Swati Sharma - Online Submission from Des Allen of ActewAGL Distribution (support)

17 December 2010

Googong Water Cycle Project
Application Number: 08_0236

Figure 5.5 Layout and staging of the bulk water pumping station

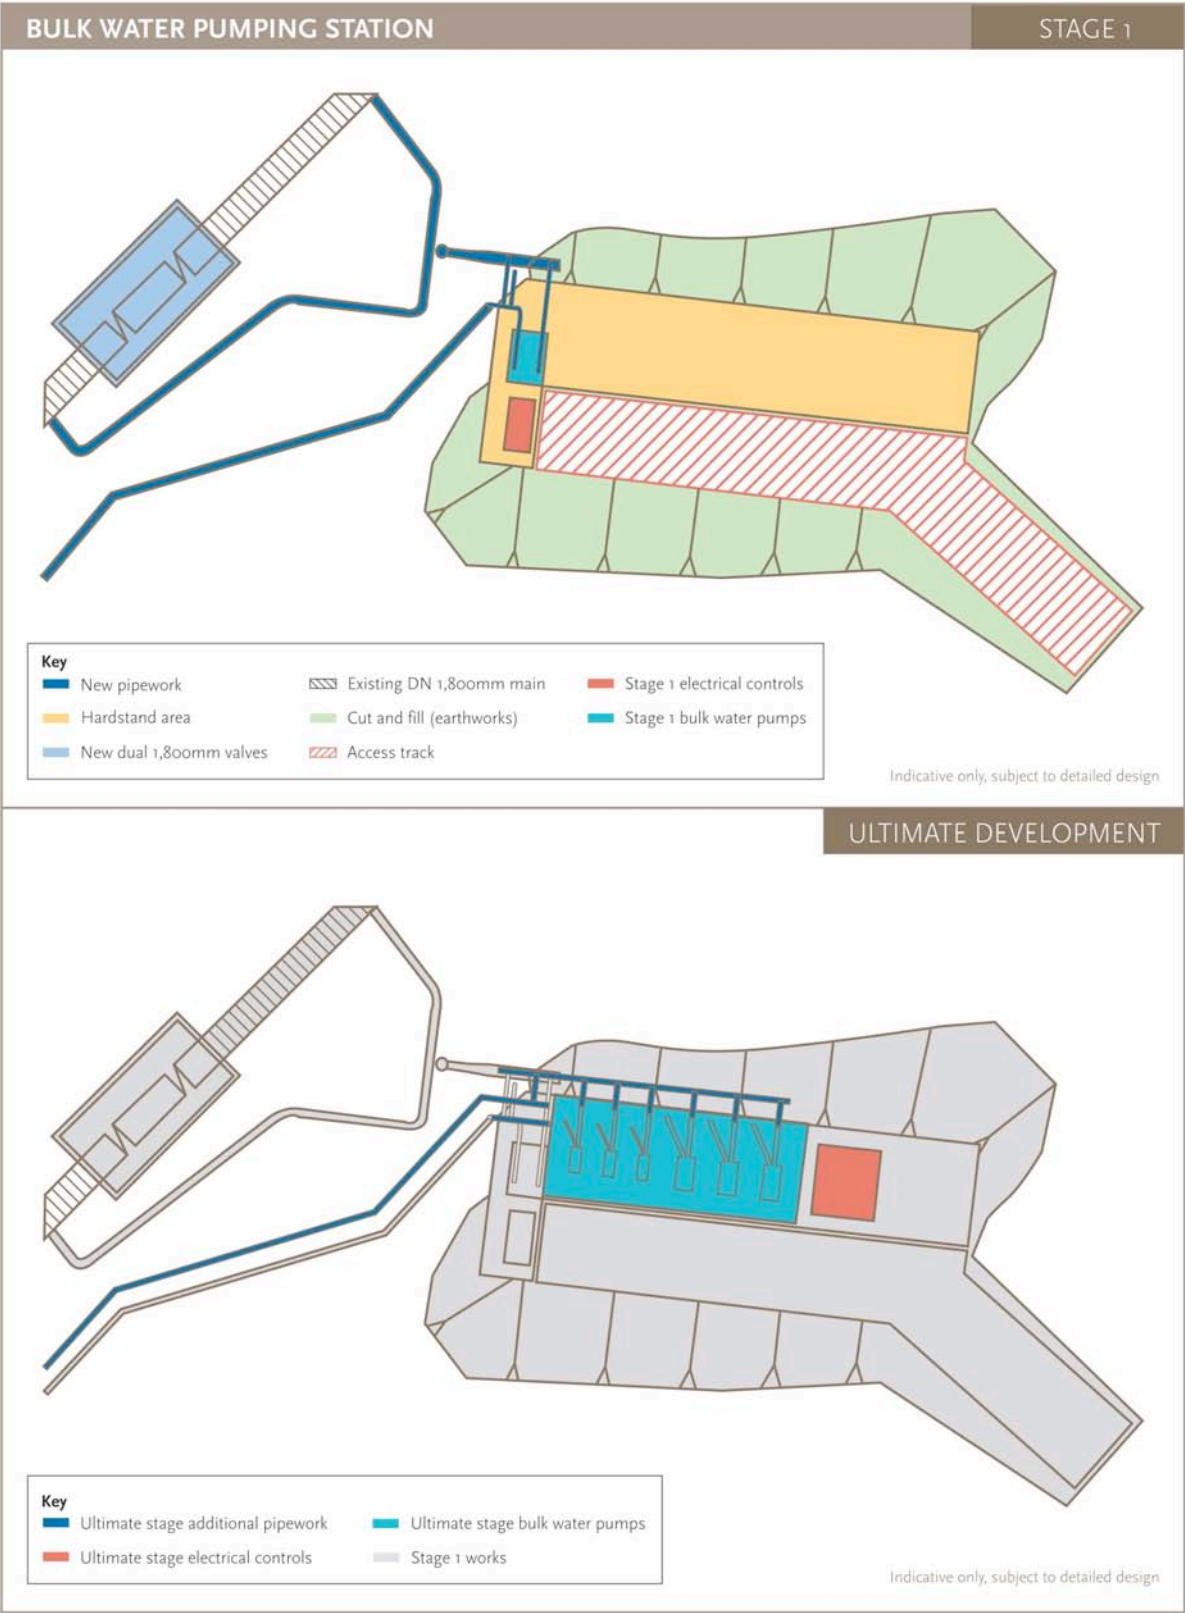
Our comment is in the way of a clarification of the various drawings included with the abovementioned document that show the new bulk water pumping station located to the East of the ACTEW owned main and with its new delivery main passing through the site of the Googong water treatment plant, onto the new Googong estate. A new arrangement has now been agreed between ACTEW and the developer whereby the new pumping station will be located to the West of ACTEW's main, and the delivery main to the estate will pass completely outside the Googong water treatment plant. The developer's main will enter onto the Googong Dam road further to the West and closer to the proposed estate development.
